From: Thomas Callaway
Sent: 05 December 2014 15:46
To: Planning.Responses
Subject: RE: Planning Consultation on Y/95/14/DOC

Registered: 14-NOV-14
Site Address: Land to the Rear of Burndell Road Yapton BN18 0HR

Description of Works: Application for approval of matters reserved by condition imposed under Y/48/13/ relating to condition 4 for surface water

Project			
Goodhew Close Phase 2, Yapton			
Title			
Soakaway Locations			
Scale		Date	Drawing No.
1:500@A1		Nov 14	4822:505
Checked		Drawn	Rev
TC		AMc

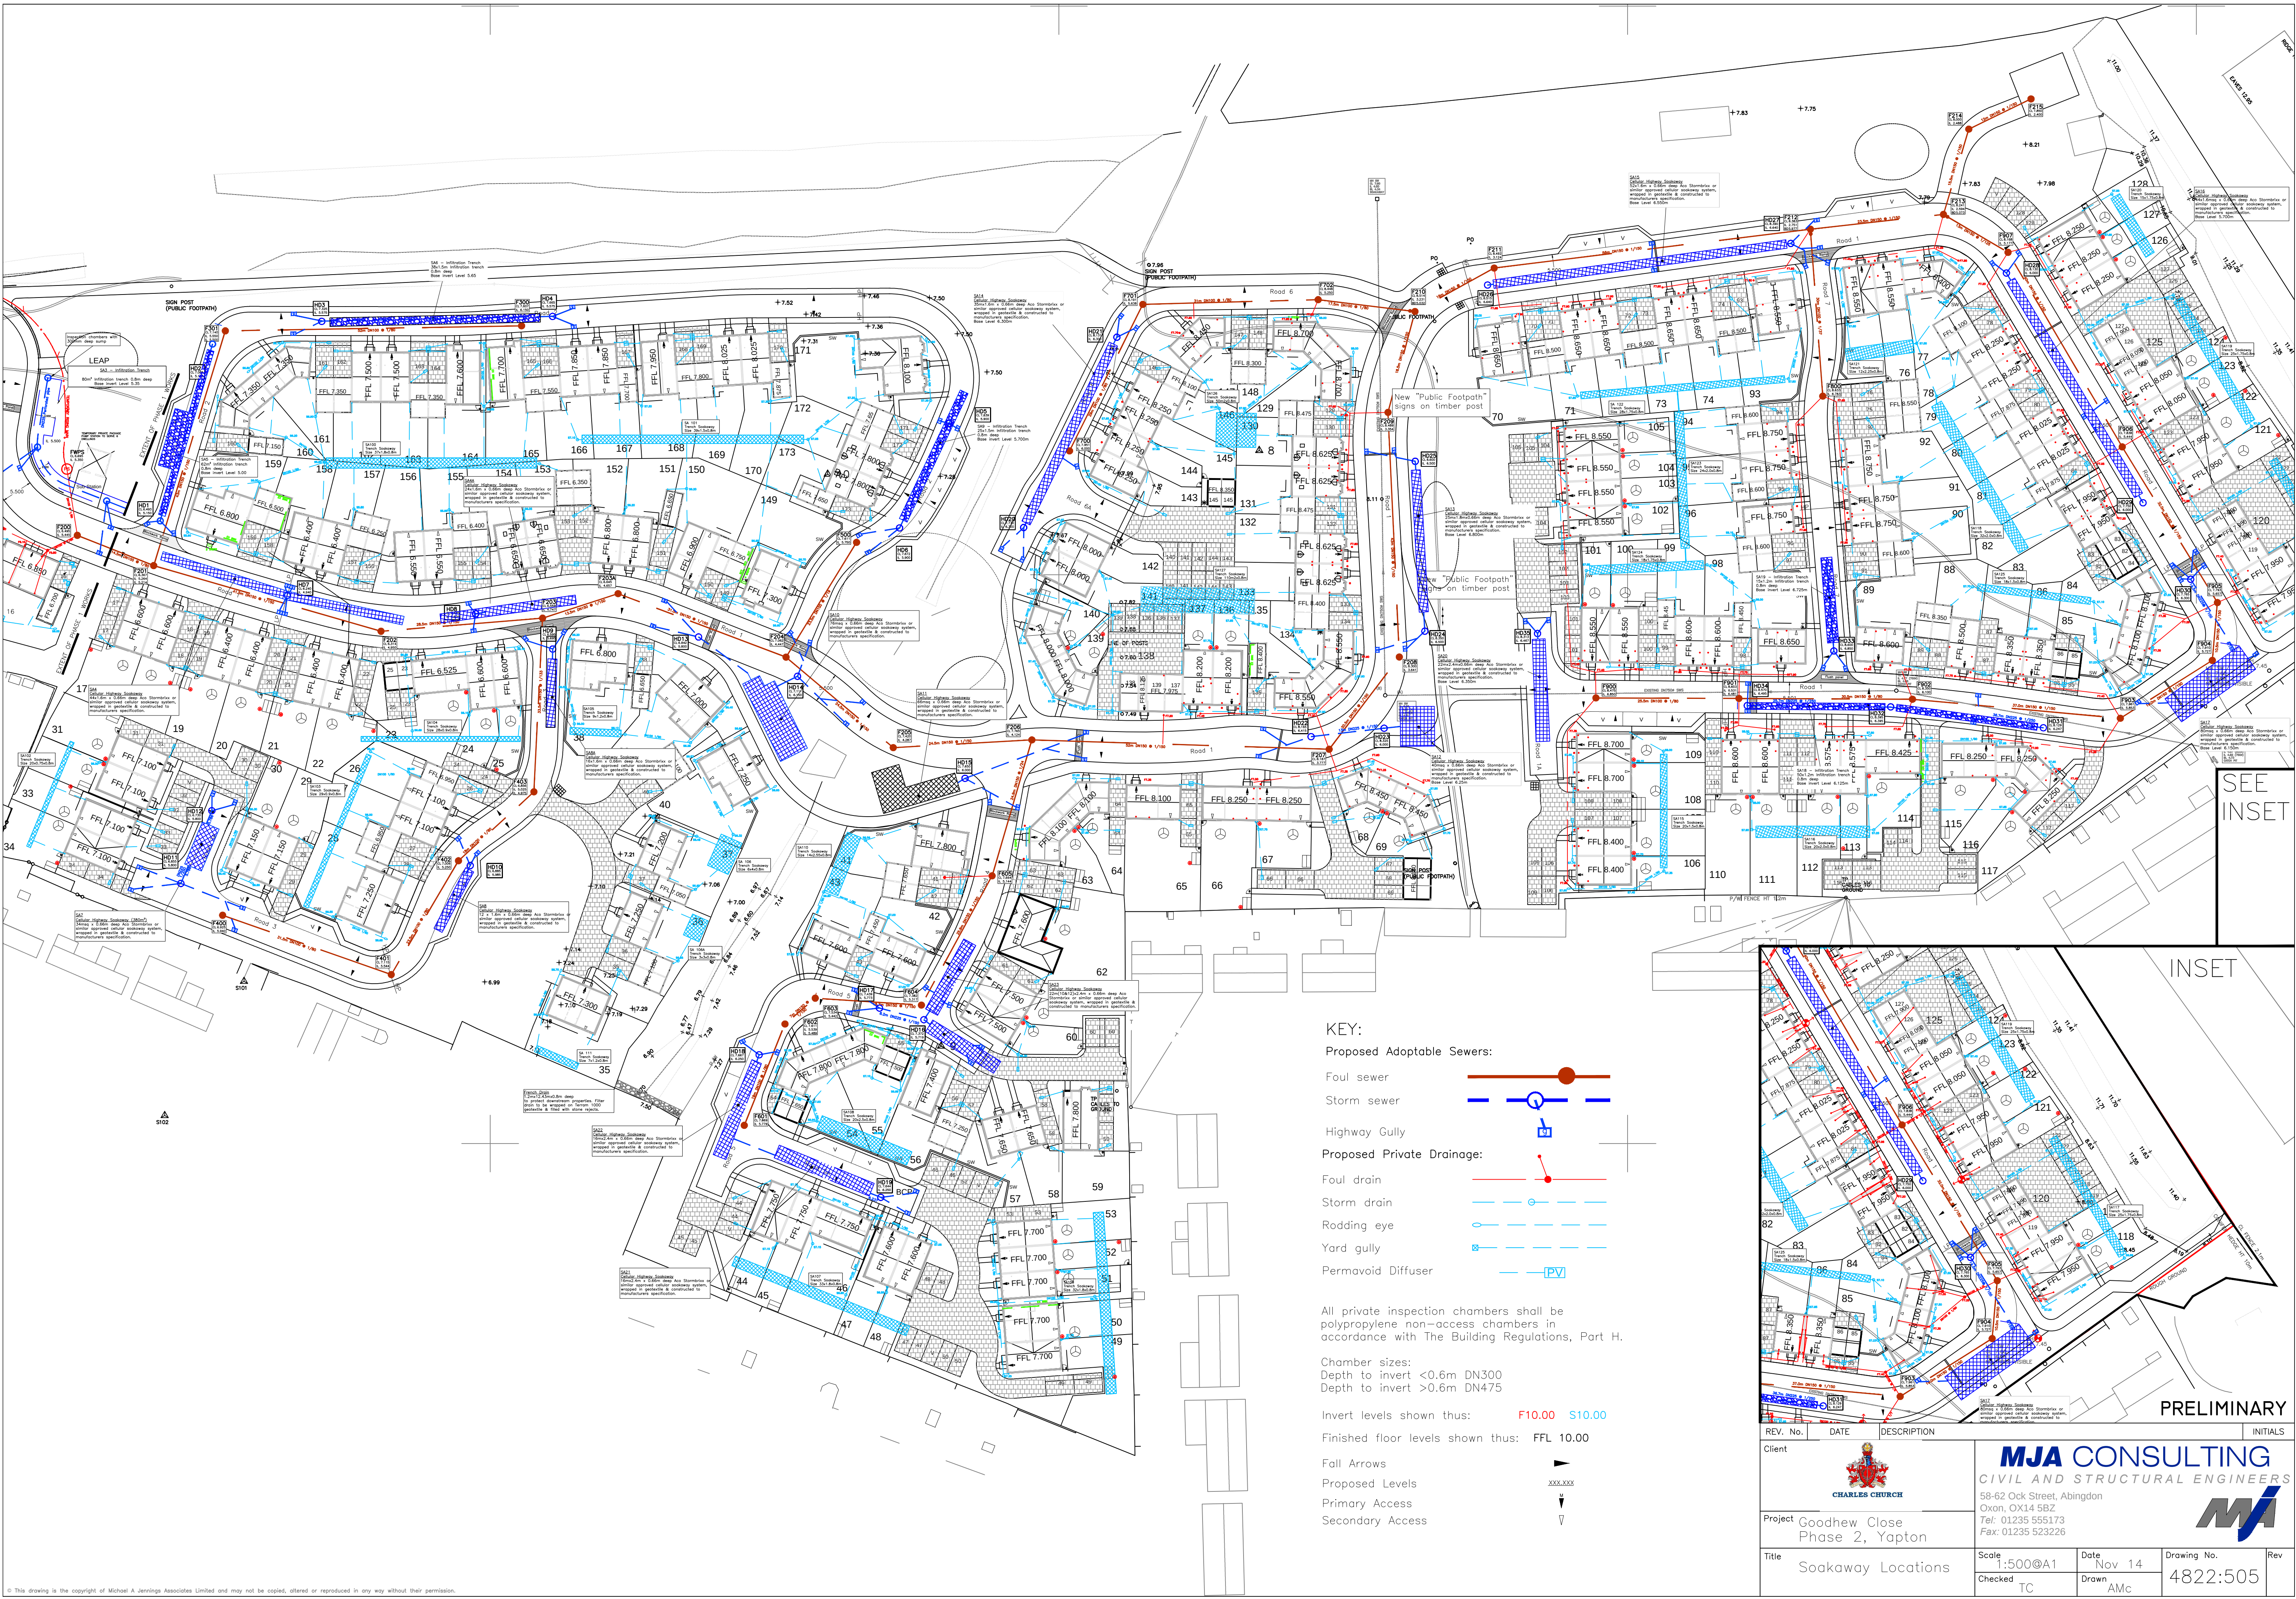
Surface water drainage details have been submitted in accordance with my additional comments requested for the first phase. Also the cutoff drain adjacent to an existing property south of the development has been incorporated.

The surface water drainage condition may be discharged.
